BEFORE THE HEARING EXAMINER OF THE CITY OF MERCER ISLAND

Case No. APL24-002

APPELLANT DANIEL GROVE'S
CORRECTED PRE-HEARING
MEMORANDUM AND RESPONSE TO
DOROTHY STRAND AND THE CITY
OF MERCER ISLAND'S REQUEST
FOR DISMISSAL

BASEMENT FLOOR PLAN

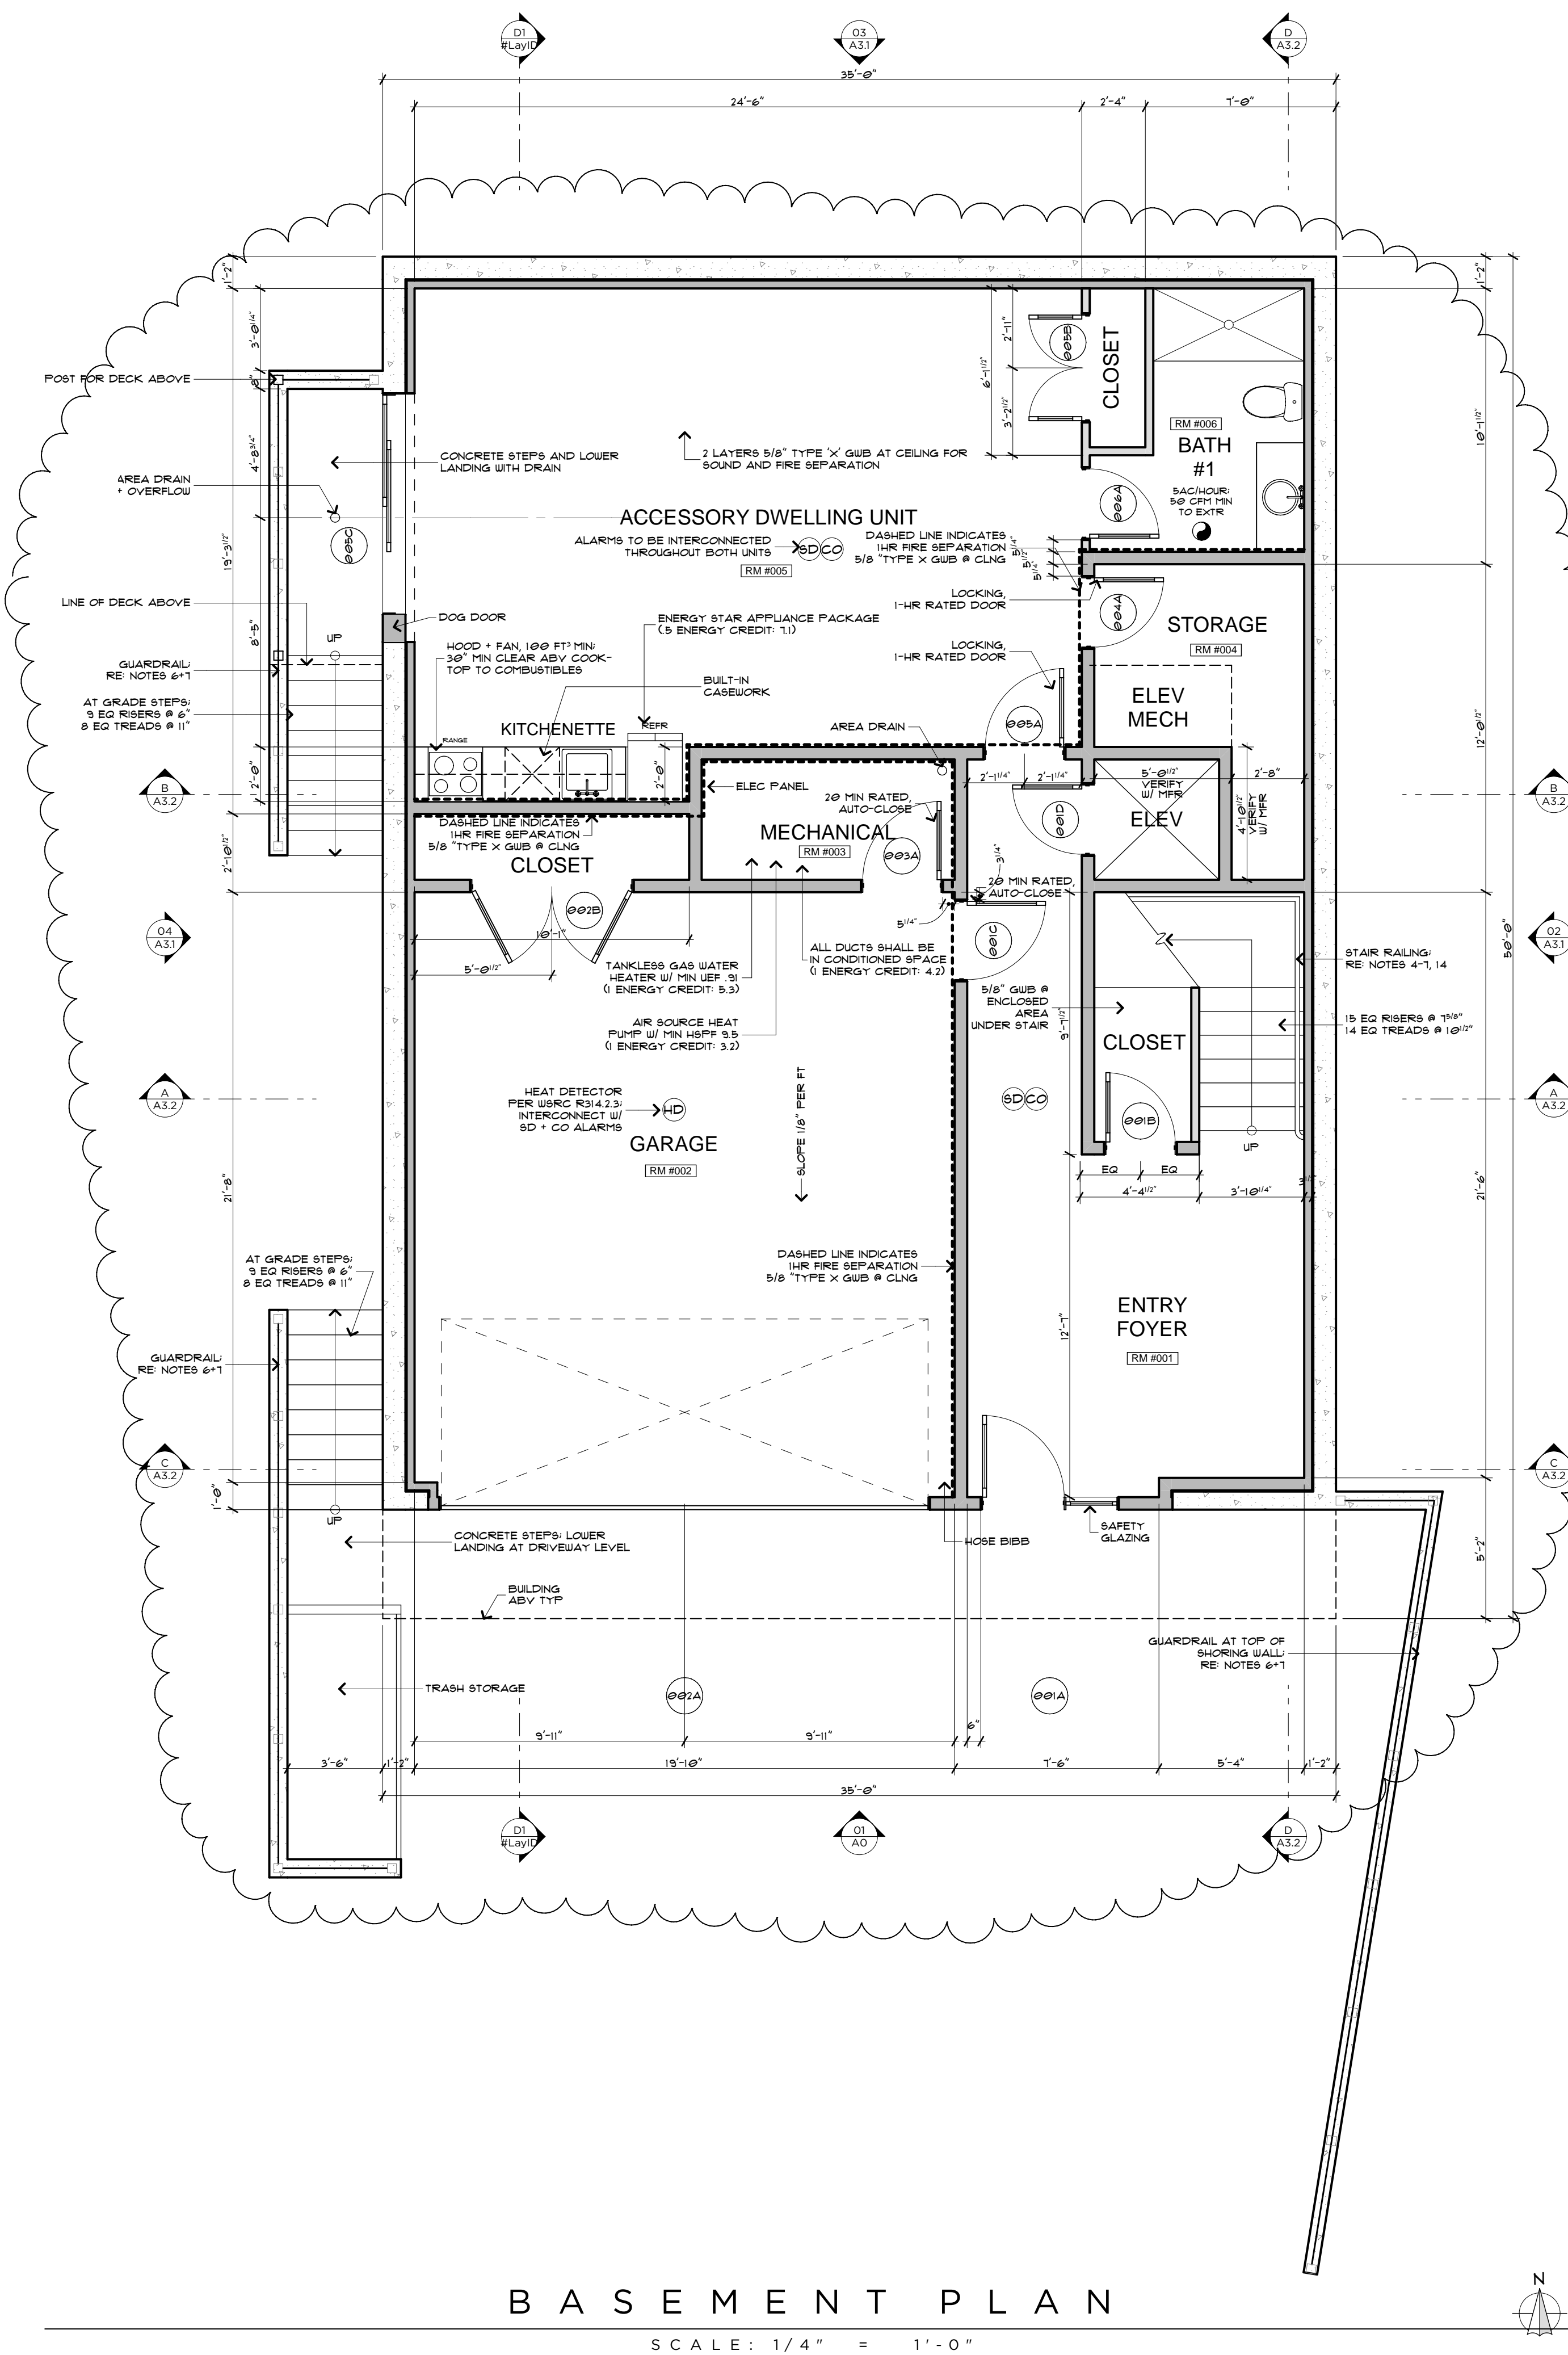
2 First, Ms. Strand misstates Mr. Grove’s analysis—at no point did Mr. Grove attempt to
3 “link” the basement exclusion area to ABE. Strand Motion at 6. Instead, Mr. Grove explained that
4 incorrect determinations of both “existing grade” and “finished grade” resulted in a larger gross
5 floor area (“GFA”) than permitted. Grove Appeal at 7. A correct GFA calculation relies on both a
6 correct calculation and correct use of “existing grade” and “finished grade.” See MICC Title 19,
7 Appendix B. Again, this is because a portion of the basement floor area (called the basement
8 exclusion area, which is used as part of the GFA calculation) can be excluded by the developer
9 depending on which is lower—the existing or finished grade. *Id.* The Final Plan Set calculated a
10 basement floor exclusion area of 937.5 square feet, Final Site Plan at A1.0, while the actual
11 basement exclusion area to be used is closer to 613 square feet. Thus, the incorrect calculations

12 and use of existing and finished grade resulted in a smaller basement floor exclusion area than is
13 used in the Final Plan Set.

14 Second, Ms. Strand incorrectly uses midpoint elevation to compute a basement wall
15 coverage of 59.37% (4’9” / 8’), rather than the “the portion of an exterior wall below existing or
16 finished grade, whichever is lower.” This is a difference of 21.36% (59.37% minus 38.01%). This
17 error alone results in 98 square feet being impermissibly added to the allowable gross floor area.

18 Third, the “manual inspection” that Mr. Grove refers to was necessary because Ms. Strand
19 continuously refused to provide information necessary to fully compute the wall segment
20 coverage, another reason why Mr. Grove requests the Hearing Examiner remand to the City for
21 further review. To make the above clear, below is a summary of the basement coverage area of the
22 western basement wall based on manual inspection:
